**KIRKLEES COUNCIL  
TOWN AND COUNTRY PLANNING ACT 1990  
HIGHWAYS DEVELOPMENT MANAGEMENT**

**PLANNING REF** 2018/62/91490/E0/LC  
**CATEGORY** Minor

**PROPOSAL** DEMOLITION OF NURSING HOME AND ERECTION OF 8 DETACHED DWELLINGS WITH ASSOCIATED LANDSCAPING, BOUNDARY TREATMENT AND VEHICULAR ACCESS

**LOCATION** HOLME HOUSE CAR HOME  
OXFORD ROAD  
GOMERSAL  
CLECKHEATON  
BD19 4LA

PROPOSED SITE PLAN 1:200 @ A1

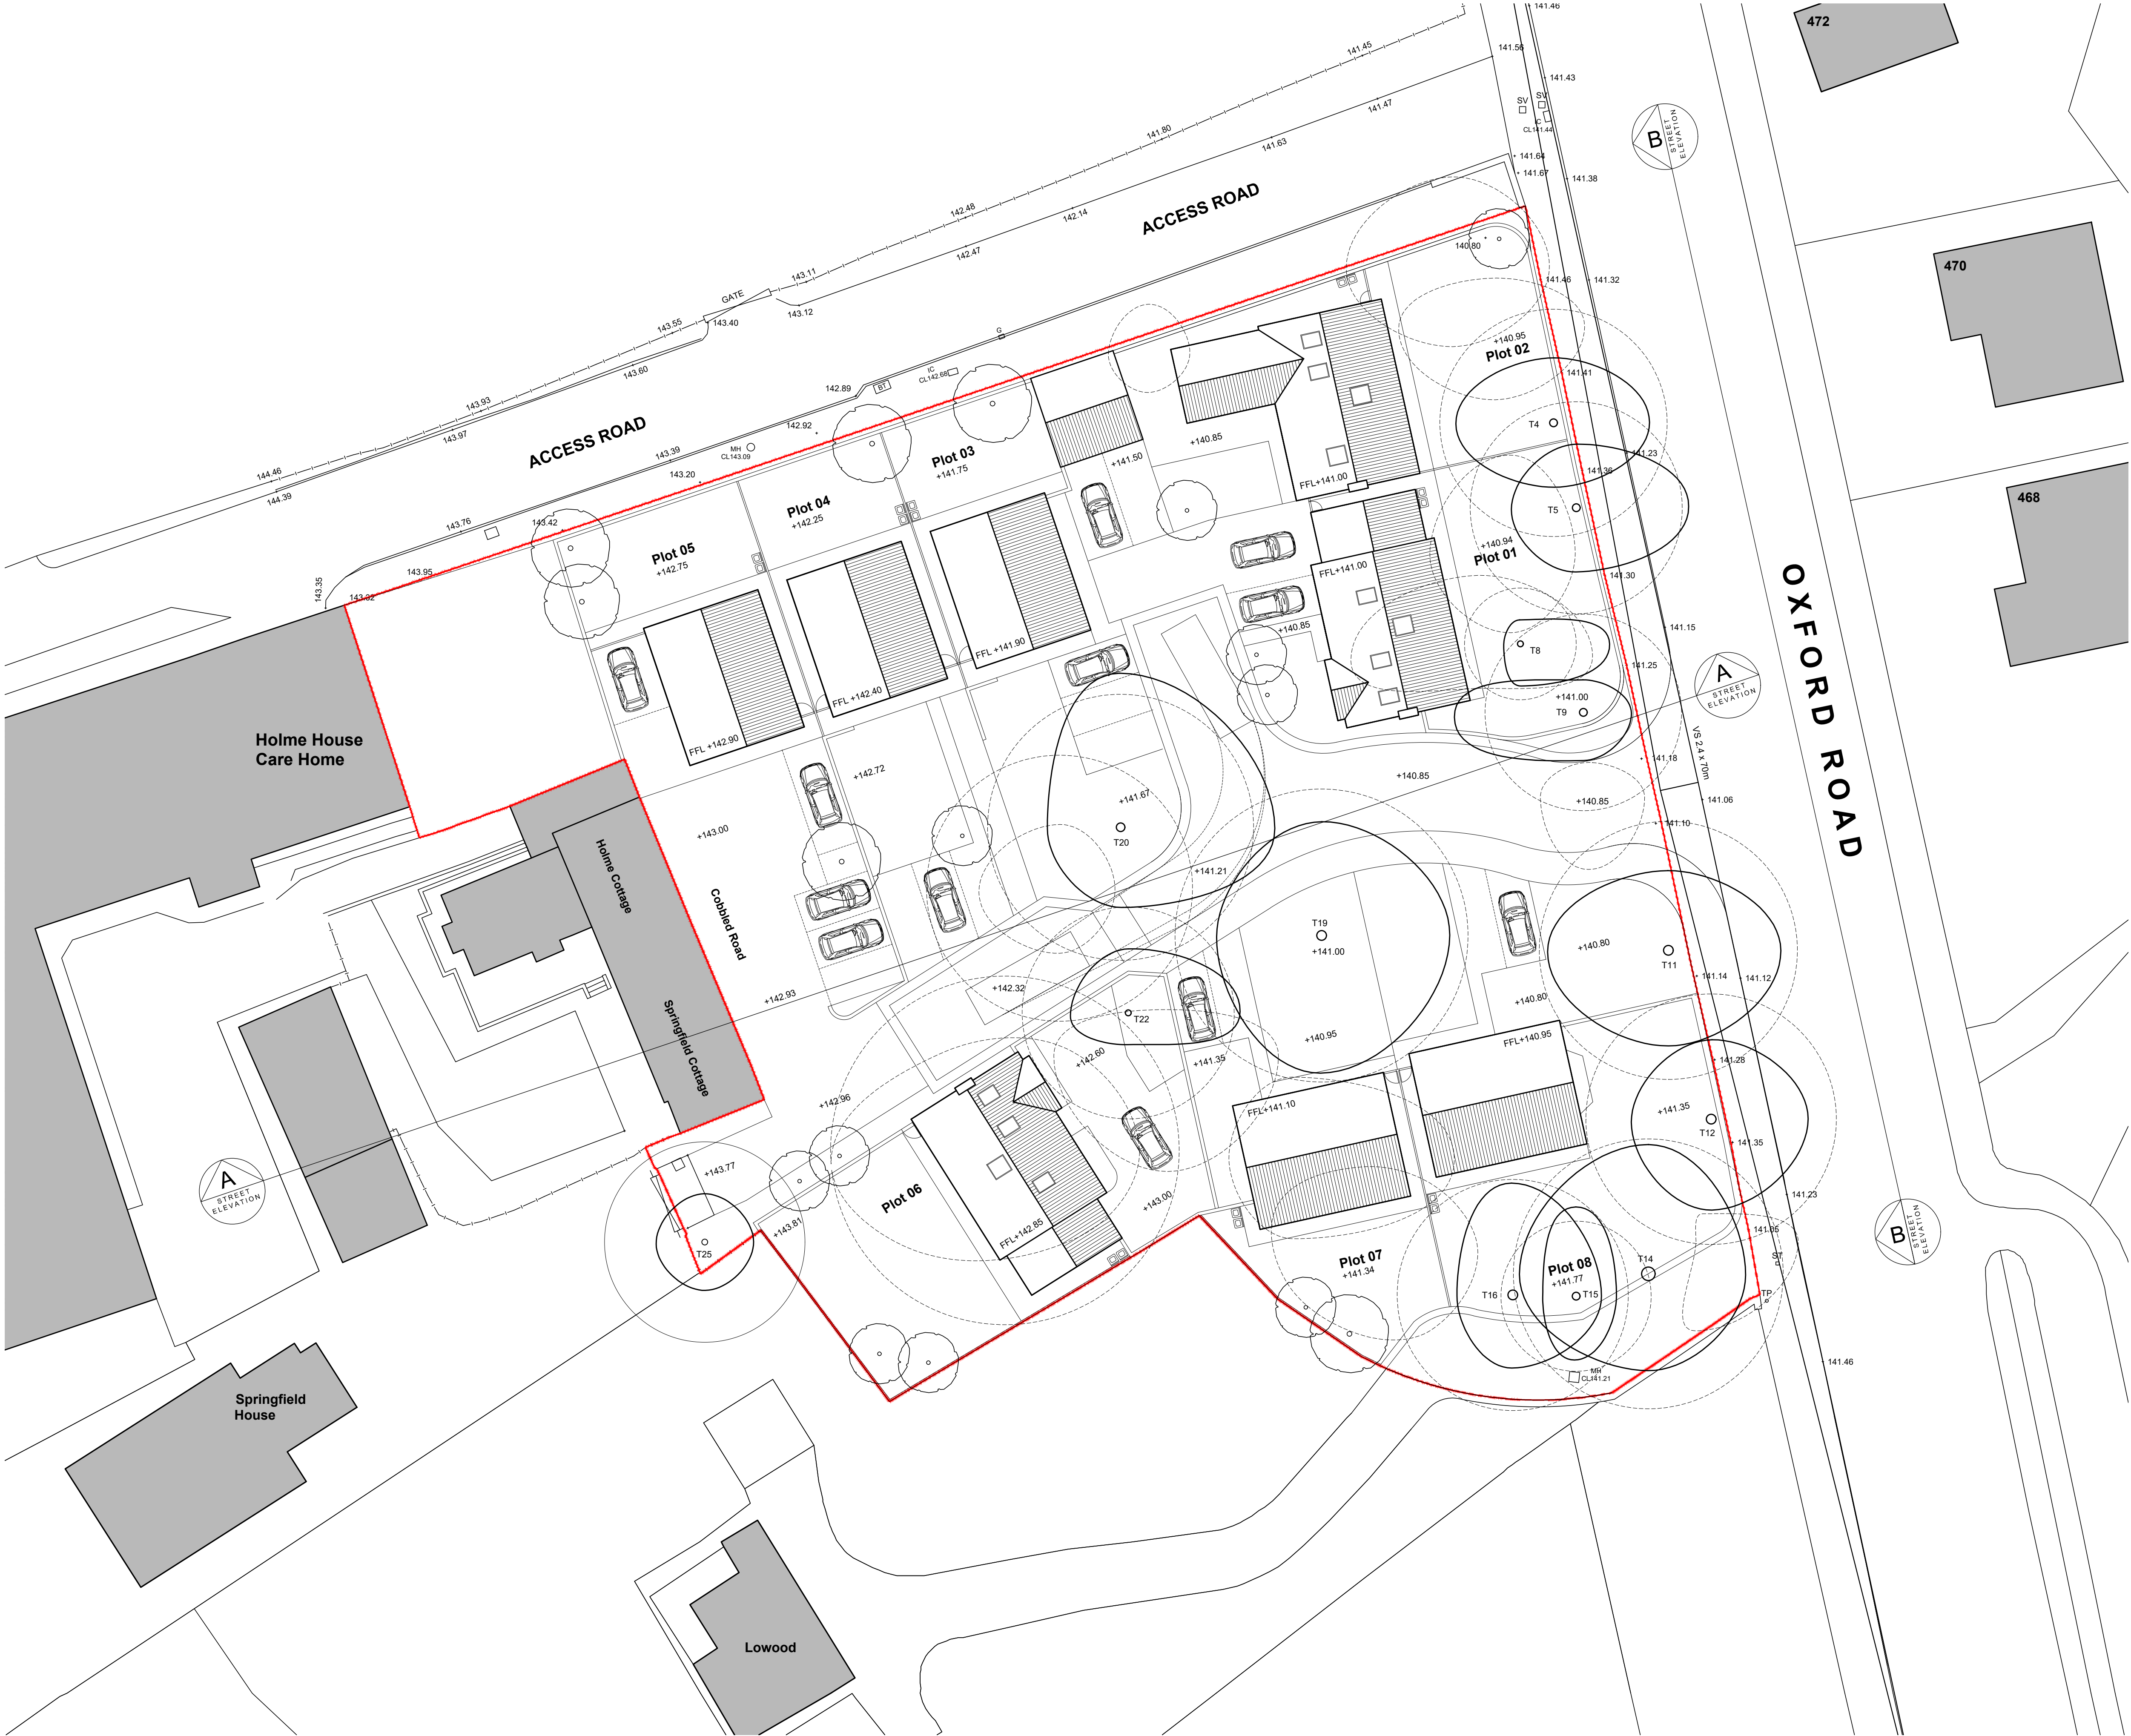
Further to the consultation response dated 1st June 2018 the applicants have provided revised proposals including plan numbers 1626 - D - 20 - 004 - B Proposed site Layout and YK5775 - 100 - 001 Swept Path Analysis Refuse Vehicles.

These plans demonstrate that the proposed turning head and access road are sufficient in size to accommodate an 11.85 m refuse vehicle.

Plots 7 and 8 now have 3 off-street parking spaces.

Bin collection points are shown to each dwelling.

These proposals are considered acceptable to Highways Development Management and we have no wish to resist the granting of planning permission.
